From: Maria Tomalova <Maria.Tomalova@arun.gov.uk>
Sent: Wednesday, September 13, 2023 5:22 PM
To: Planning.Responses <Planning.Responses@arun.gov.uk>
Subject: FW: Y/105/19/PL & Y/106/19/L

Y/105/19/PL & Y/106/19/L

The proposal is for the conversion of, and alterations to, existing barns to create 3 dwellings, along with the erection of car barns, a store, a replacement pump house, demolition of a C20 barn and associated landscaping and parking.

Drawing Title	Proposed Plans - Barn 3
Scale	1:100 @ A3

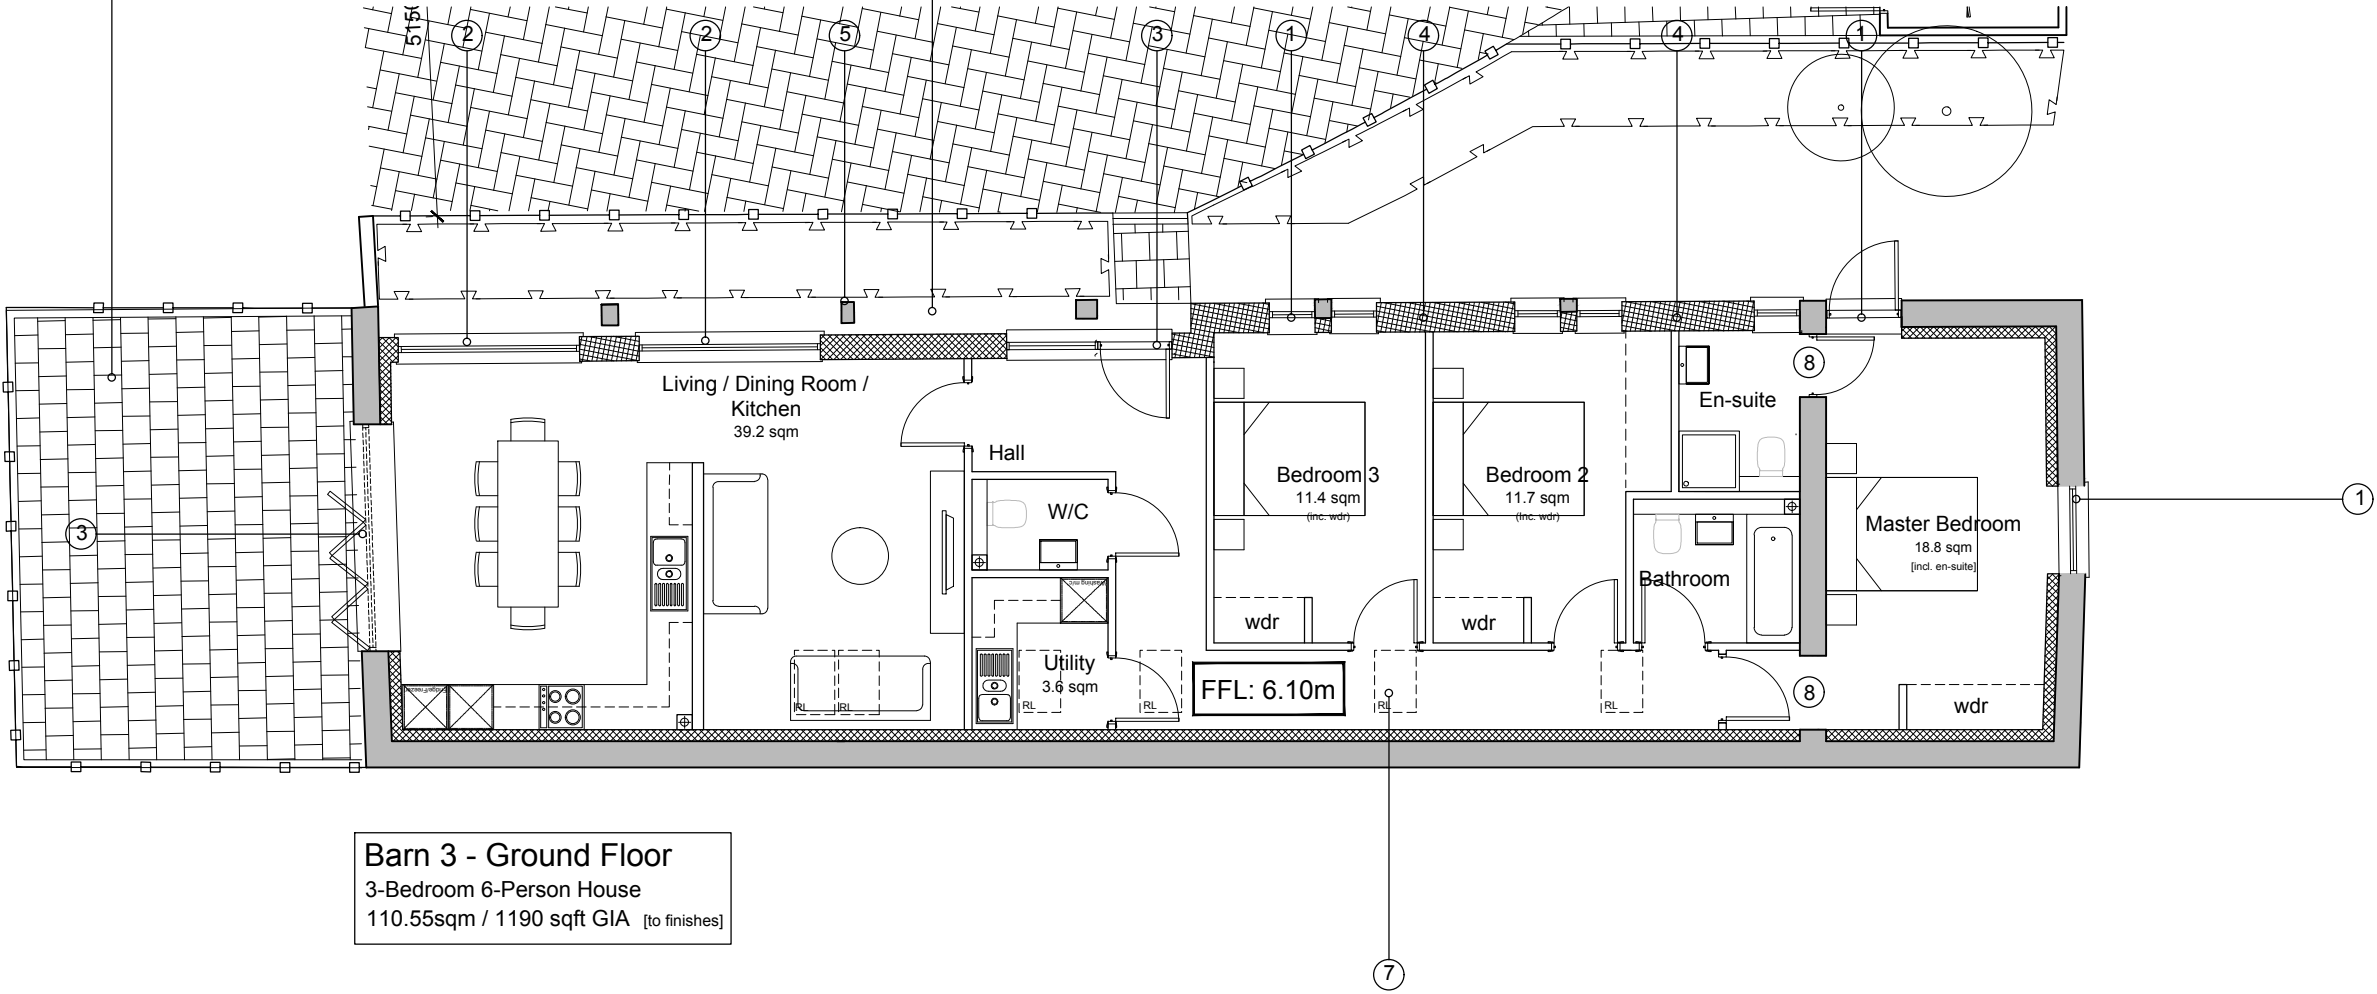
Likewise, it is noted that the building referred to as 'barn 3' is to include bi-folding doors. Such a feature is not normally associated with a barn and cannot be supported here. It is suggested that an alternative approach be considered which would result in the loss of less historic fabric, and a more appropriate design.
